**ENGINEER'S STATEMENT**  
This Grading and Erosion Control Plan was prepared under my direction and supervision and is correct to the best of my knowledge and belief. Said Plan has been prepared according to the criteria established by the County for Grading and Erosion Control Plans. I accept responsibility for any liability caused by any negligent acts, errors or omissions on my part in preparing this report.

**EROSION AND STORMWATER QUALITY CONTROL PLAN**

**GPAP Staging Area**

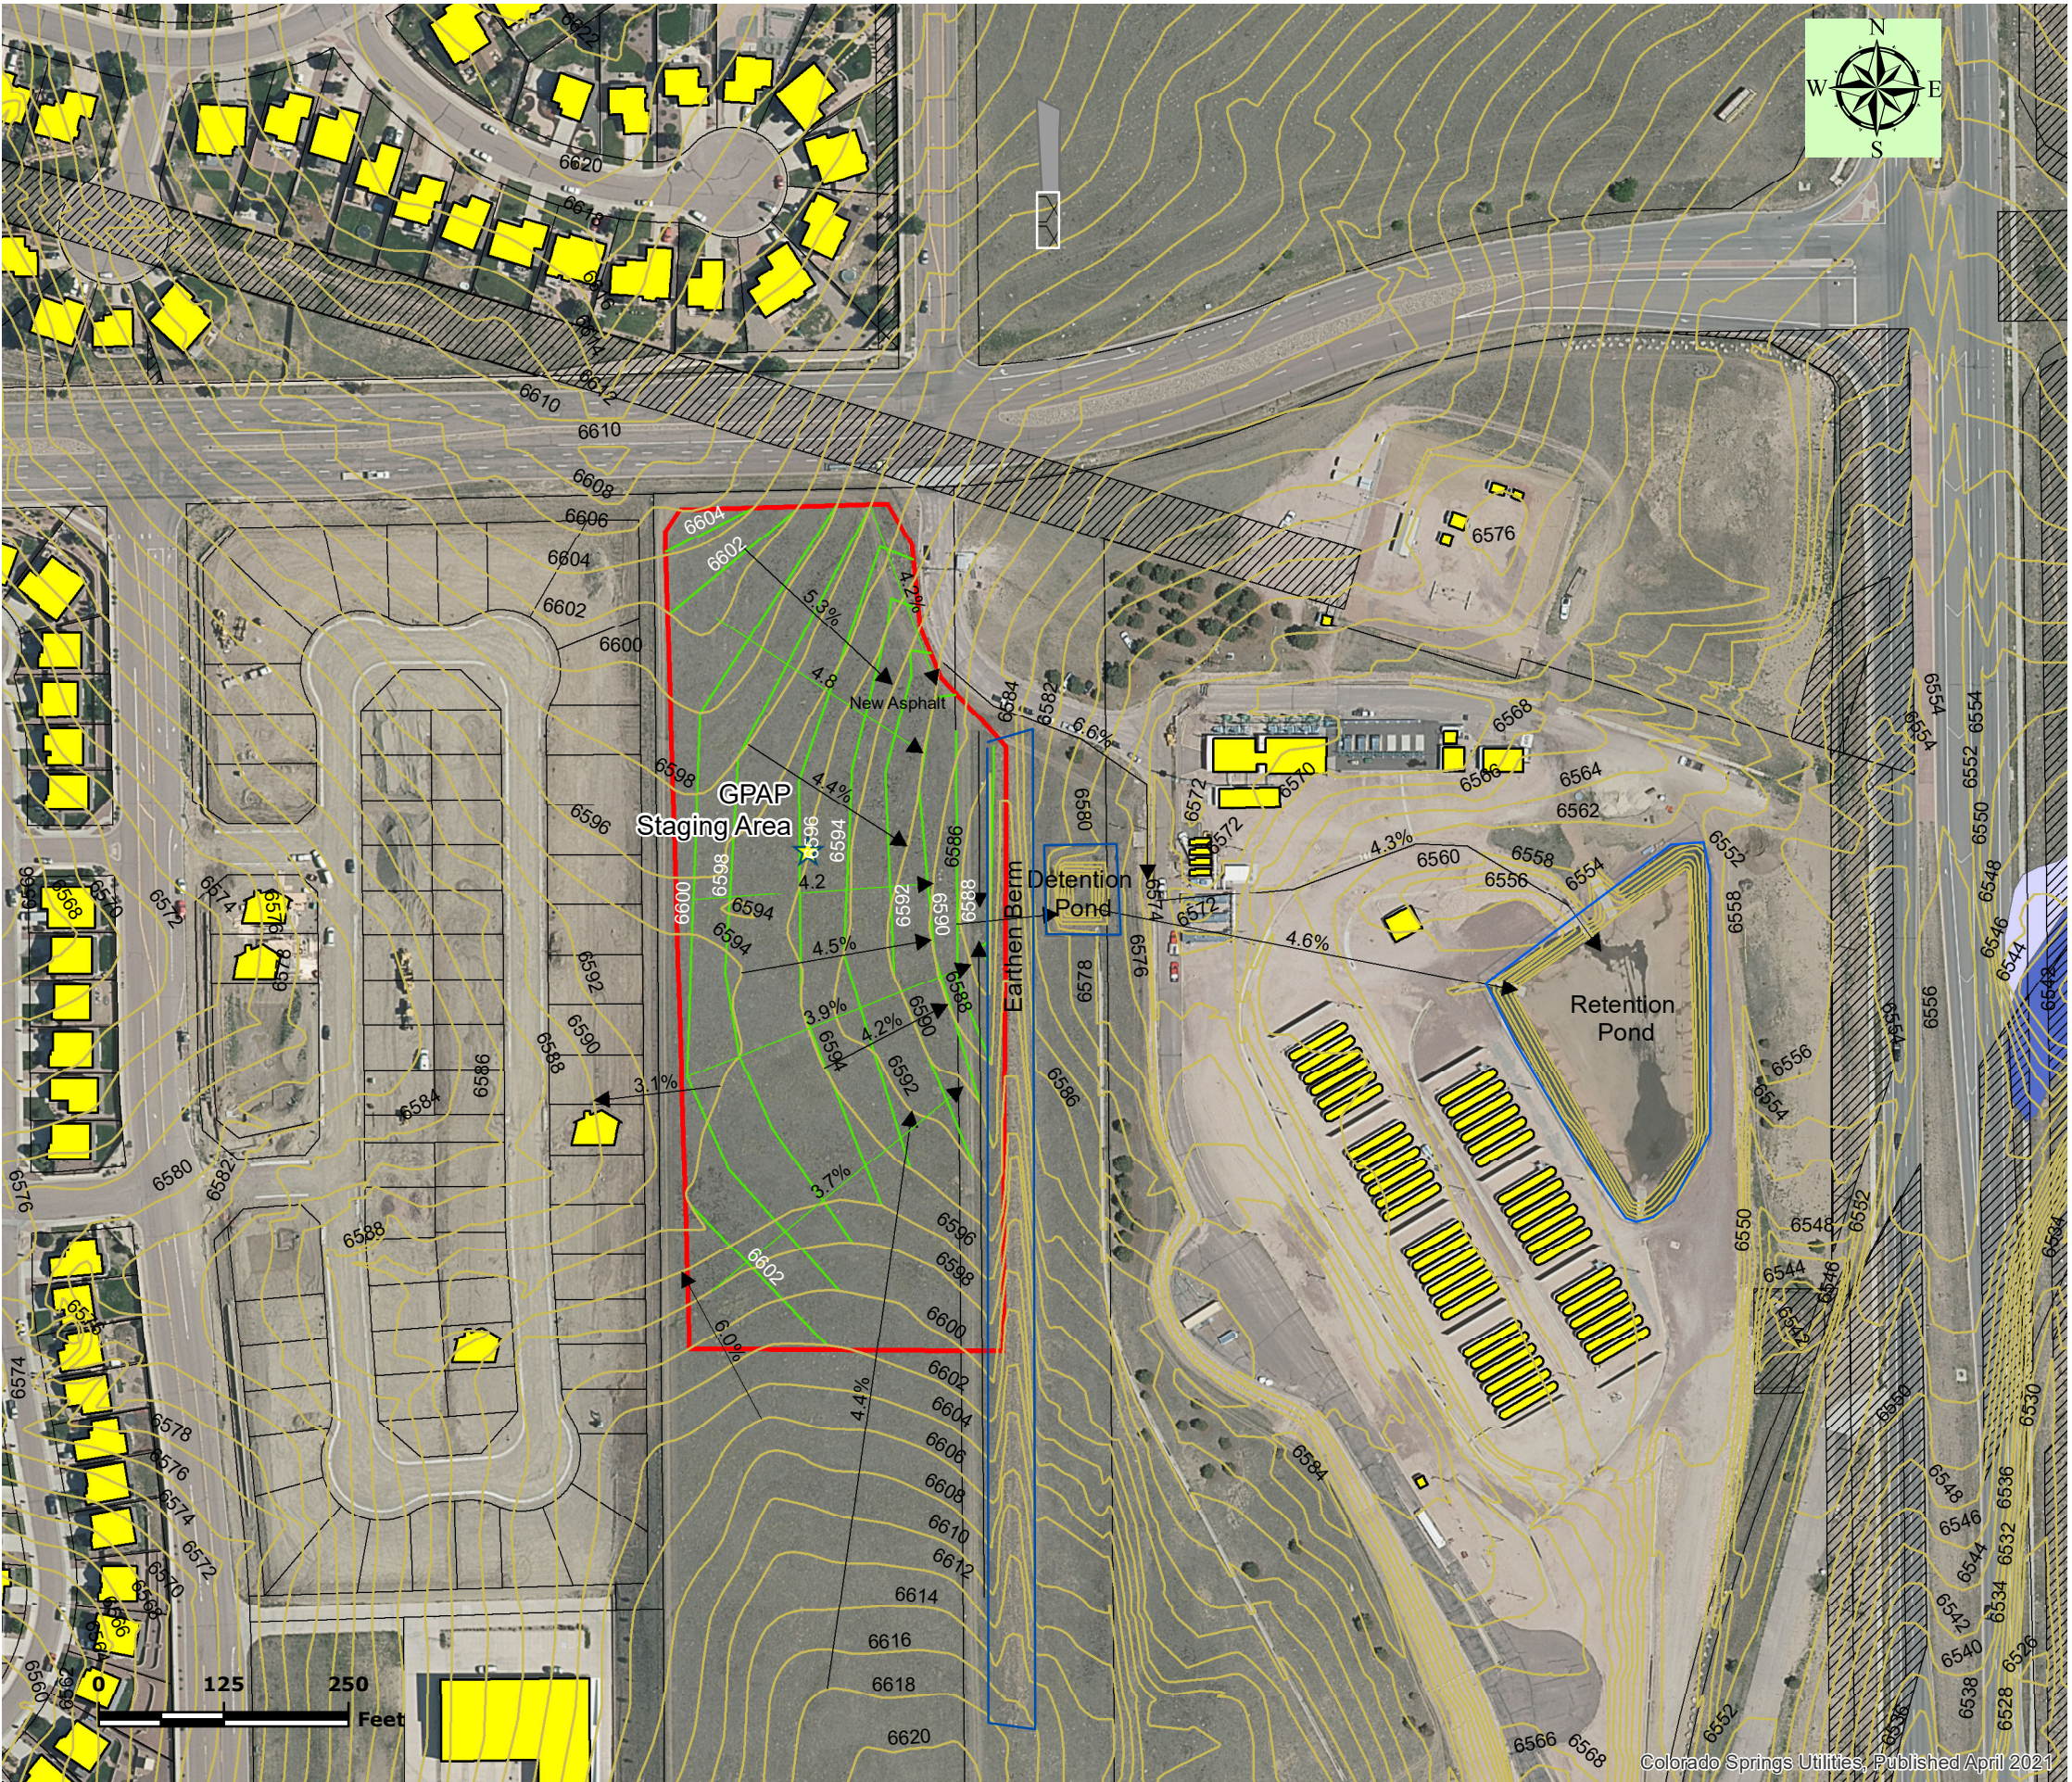
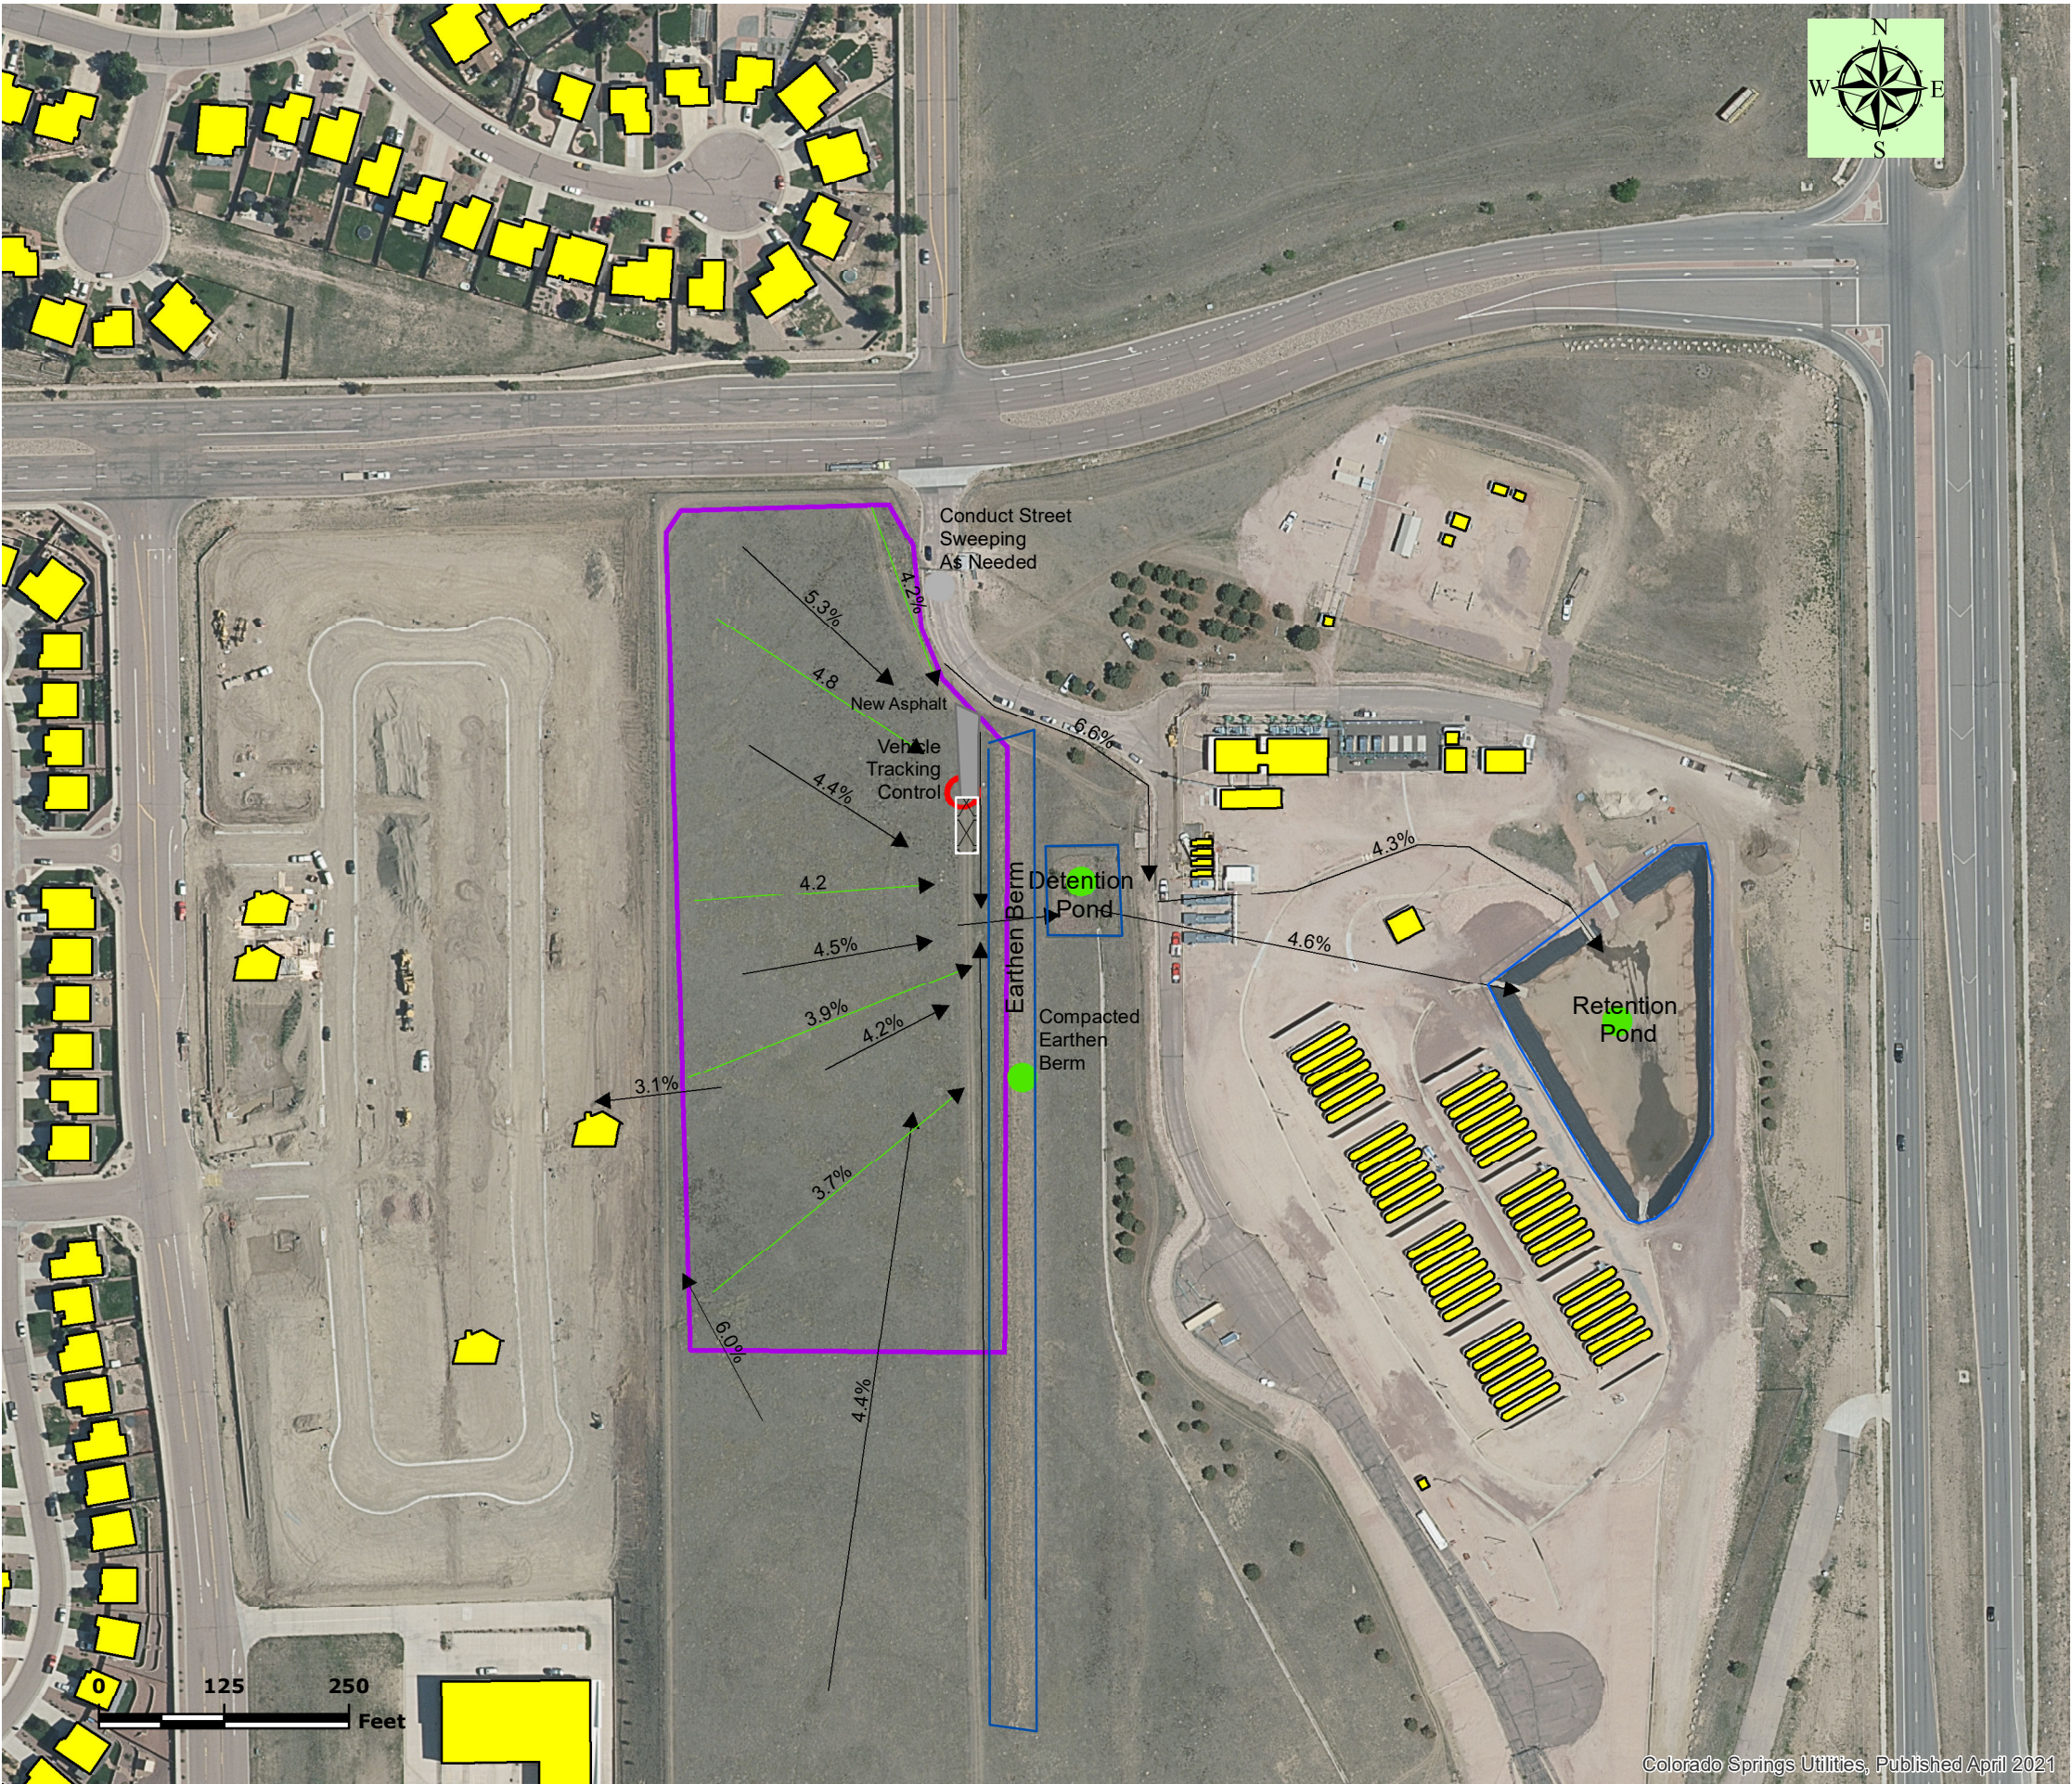
IP and CD's are not seen on Fig 4. Show their location on that Fig. FAE states that there is 1 IP and 0 CD's. Update FAE accordingly if you update plans.

Concrete Washout shown on FAE but not plans. Show location on plans and provide a detail here or remove from FAE.

VTC shown on Fig 4 and FAE but no detail shown here. Provide a detail. Make sure that the detail that you choose shows a min VTC length of 75ft.
